Shivesh Singh - Scottish Hospital Redevelopment MP10_0160

RE: 2 Cooper St, Scottish Hospital Redevelopment (MP10_0160)

RE: 2 Cooper St, Scottish Hospital Redevelopment (MP10_0160)

STEPHEN STREET ELEVATION

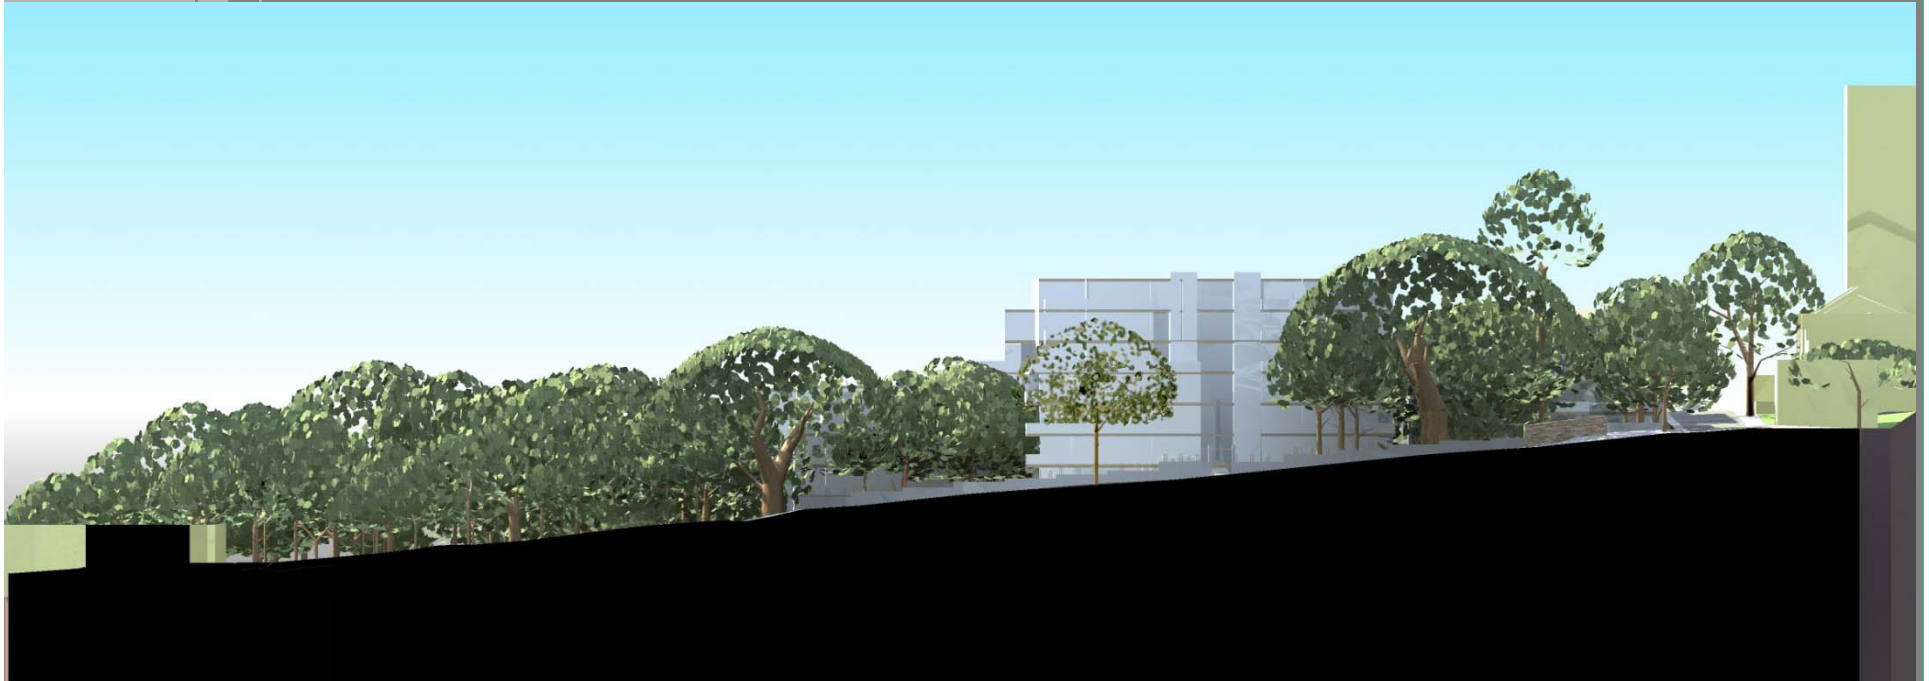
- All trees along Stephen St are slated to be removed, with the exception of two trees in the far north-east corner. The current trees are up to 19 metres tall with canopies of 6 to 8 metres radius

- This principle has been adhered to on other parts of the site, but has been disregarded for Stephen St. The proposal will place 5 to 6 storey buildings along the street edge with minimal setbacks, and in doing so remove every existing tree along the streetscape and replace them with shrubs

- The higher building forms are proposed to be located opposite 38 and 40 Stephen Street. There are ninety people living in these units – ranging from the elderly ageing in place to families with young children. To say that there will not be any impacts on neighbouring buildings is disingenuous.

- The RACF building is up to 6 storeys high (18.3 metres to roof parapet height) which is much higher than most other buildings in the local area. The local characteristic is a mix of terrace houses and two-storey walk-ups. Its height, bulk and usage are significantly different to the surrounding residential precinct.

Existing weed tree species proposed for staged removal  
From arborist report:

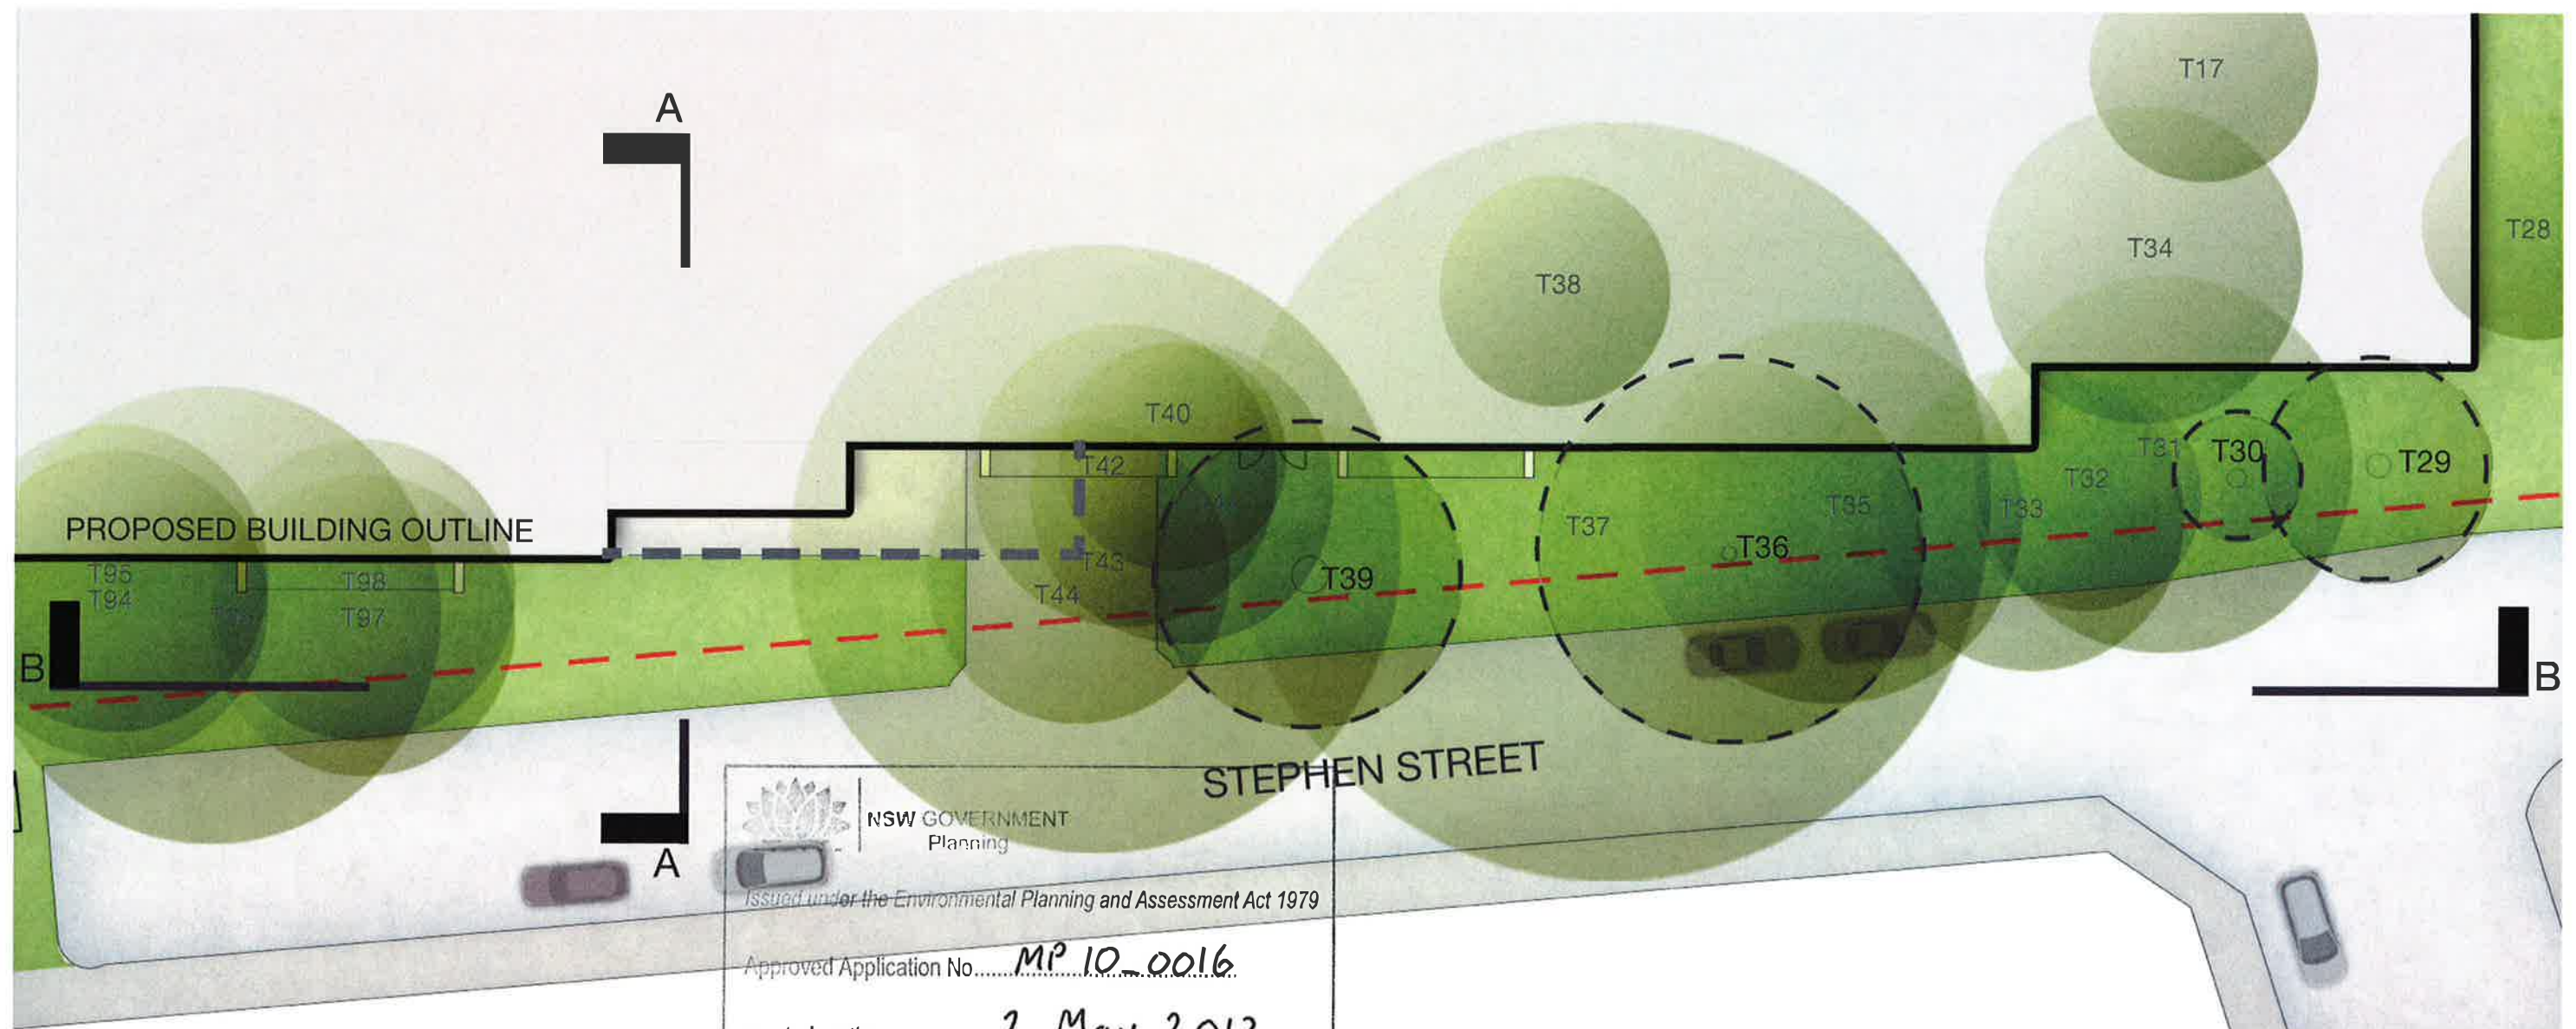
- Residents have been told that the Aborist recommended removal of all trees along Stephen Street because they are weed species. This is not correct. The report classifies nine trees located near the boundary as Retention Value B 'Could be retained'. Most are Chinese Hackberry, Camphor Laurel and Coral Trees over 10 metres tall. The Woollahra Council Tree Preservation Order (TPO) says that any trees of these species that are over 10 metres in height are subject to preservation

- Located directly opposite 40 Stephen St is T37 - a mature Camphor Laurel. This magnificent specimen is 19 metres high and 8 metres radius. It provides a significant canopy and, if it were kept, would help reduce the visual impact of the RACF building. By way of comparison, T5 near the Brown St entry is an equal size Camphor Laurel. It is also classified as Retention Value B and is being retained. This is inequitable to the residents of Stephen St.

- T35 next to T37 mentioned above is another tree slated for removal. It is a mature Brushbox which is 17 metres high and 6 metres in radius. It has Retention Value B and is located very close to the property boundary. It is not a weed species and would be an ideal candidate for retention
